Our Ref: TR010036

Date: 4 June 2019

**Application by Highways England for an Order Granting Development Consent for the A303 Sparkford to Ilchester Dualling Project**

**Examining Authority’s request for further information**

PONDS

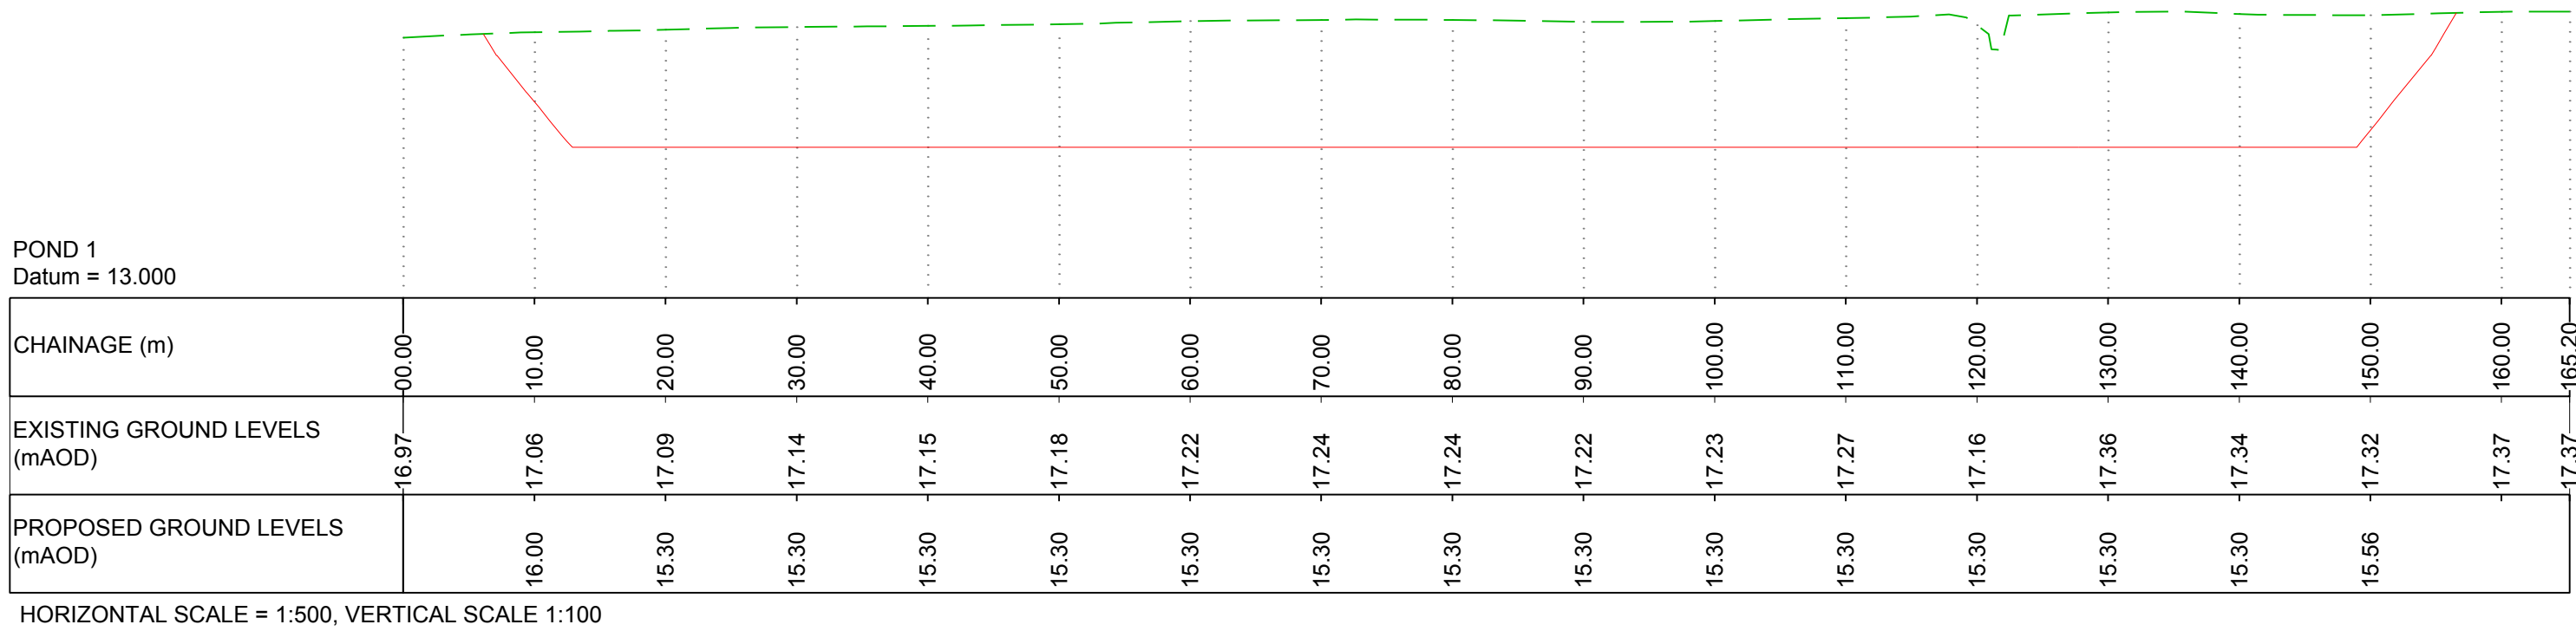
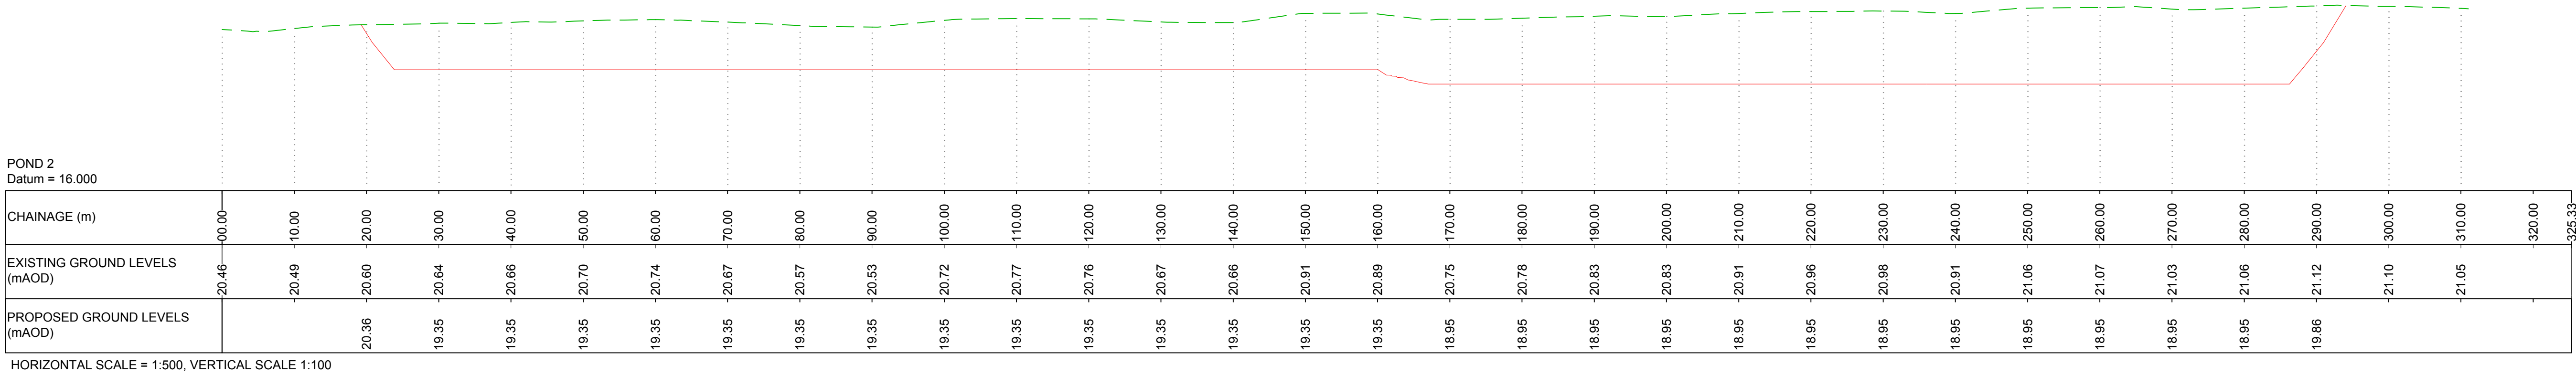
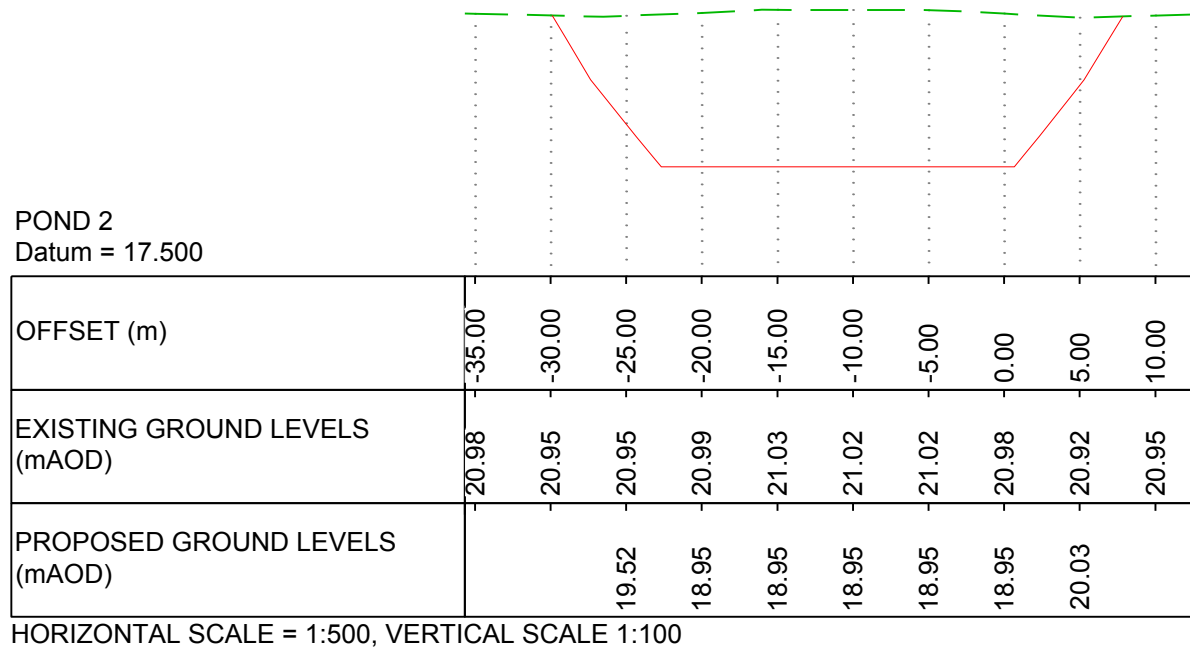
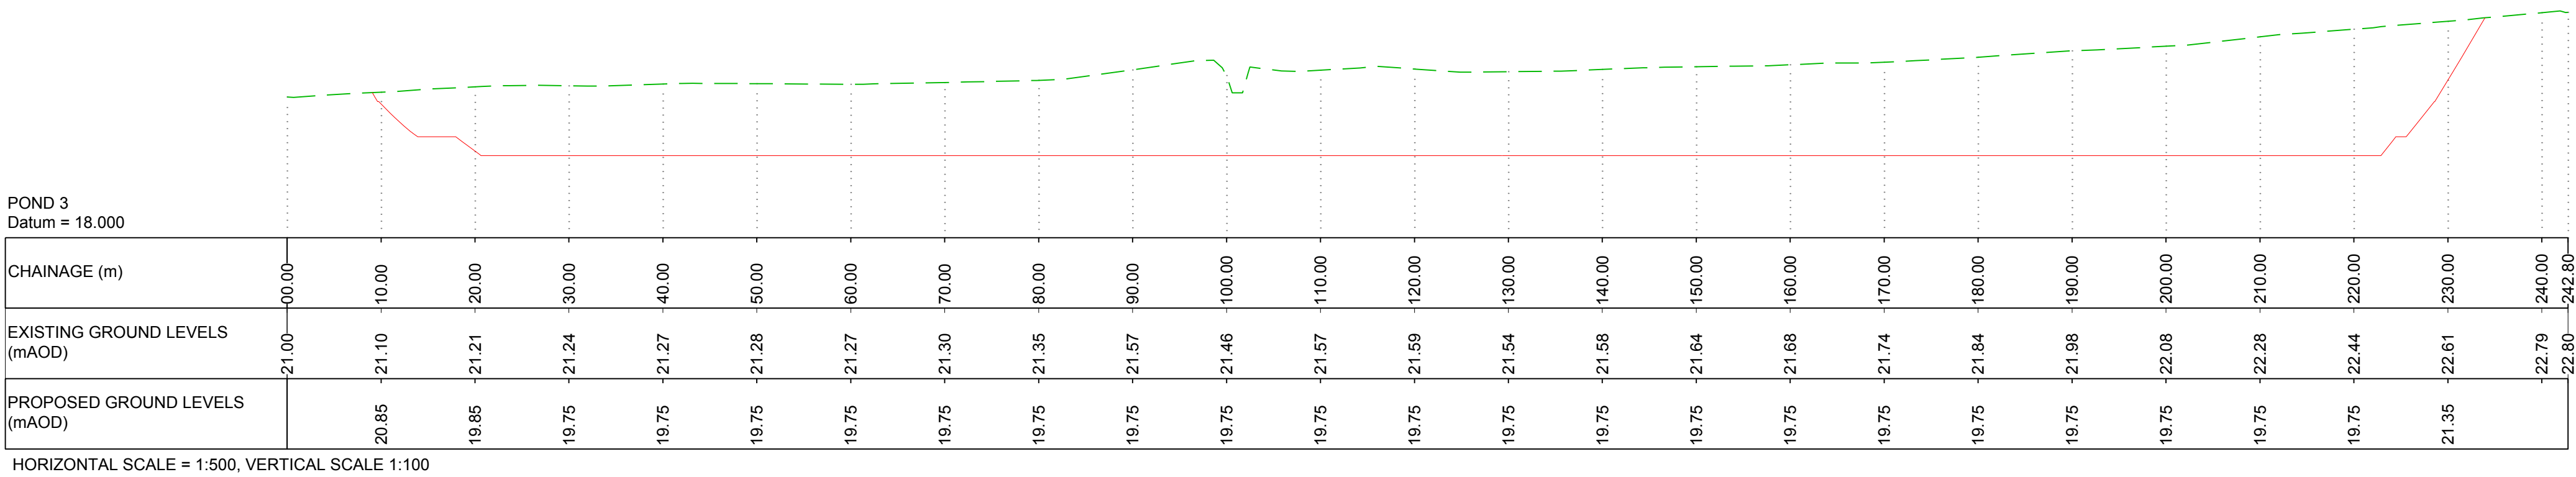
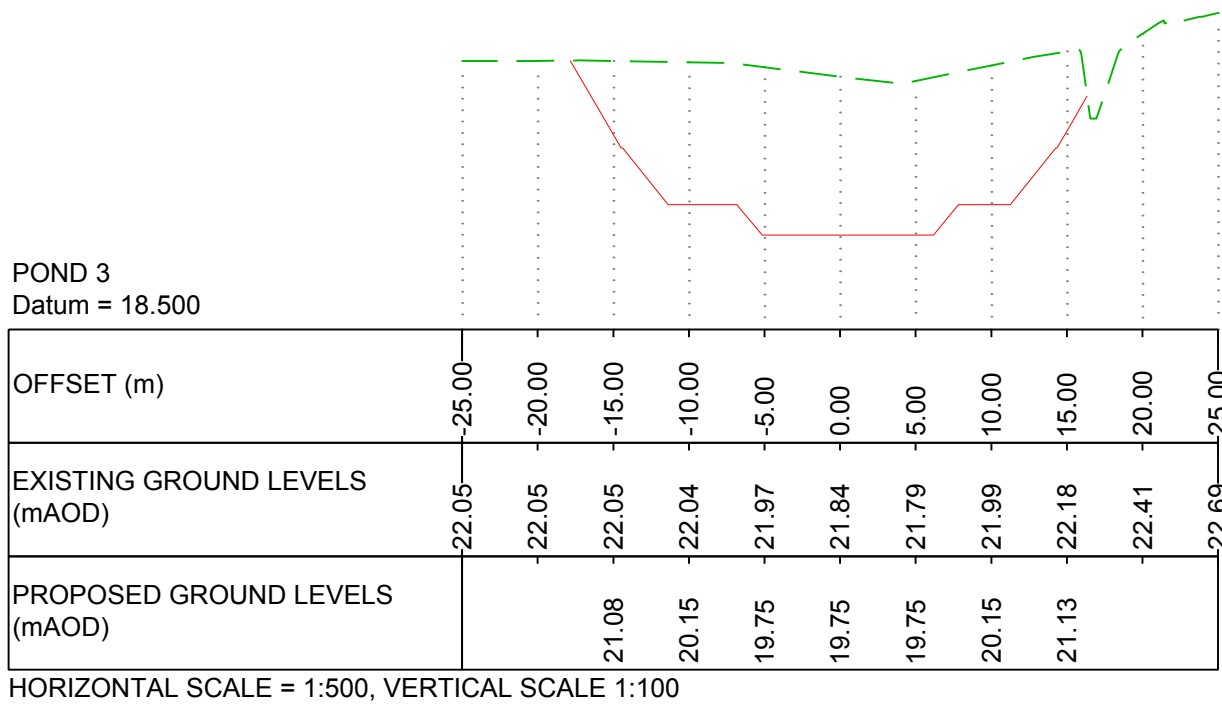
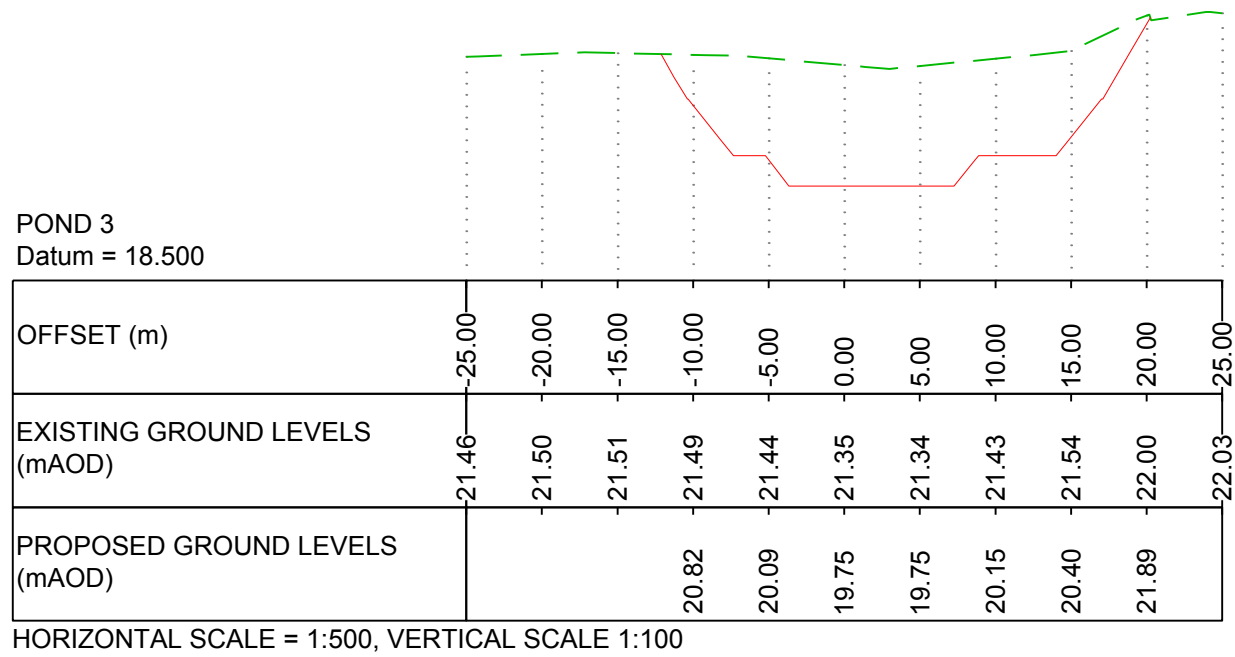
Defence Infrastructure Organisation (DIO)	<p>Potential Bird Strike. The Applicant advises that discussions are continuing with a view to limiting the risk of bird strike to an acceptable level and that this matter will be addressed within the SoCG. Notwithstanding it would be helpful to the ExA's consideration of this matter if the DIO would provide the information requested below.</p> <ul style="list-style-type: none"> <li>• An indication of usual flight paths for aircraft using RNAS Yeovilton.</li> <li>• Given the proximity of ponds 1 to 4 to RNAS Yeovilton, and the size of pond 5, could the DIO please comment on whether any modifications to the design of these ponds, including alterations to their size and number, and planting would be likely to adequately mitigate the risk of bird strike.</li> <li>• Please advise as to any limitations as to the</li> </ul>

<p>maximum size and depth of the proposed ponds that would be necessary in order to minimise the risk of bird strike.</p>
The Applicant	<p>Please supply a tracked change version of the following documents from the previously submitted versions:</p> <ul style="list-style-type: none"> <li>• Outline Environmental Management Plan (Please note the contents page also appears to need amending so that it is consistent with contents of the document)</li> <li>• Biodiversity Offsetting Metric</li> <li>• Statement of Reasons</li> <li>• Environmental Statement Table of Errata</li> </ul>
The Applicant	<p>In respect of Bund 7 could the Applicant please explain why the drainage arrangement could not be redesigned so that the two culverts are moved to the east, thus allowing Bund 7 to be extended eastward, or why the proposed culverts could not be extended in length to allow an extension of Bund 7 overhead, or why an attenuation pond could not be included on the southside of the main carriageway to avoid the need for the culverts to the north.</p> <p>If an extension of Bund 7 is not technically feasible, could the Applicant set out what alternative screening measures it has considered and why the environmental barrier (albeit a wooden fence) has been chosen.</p>
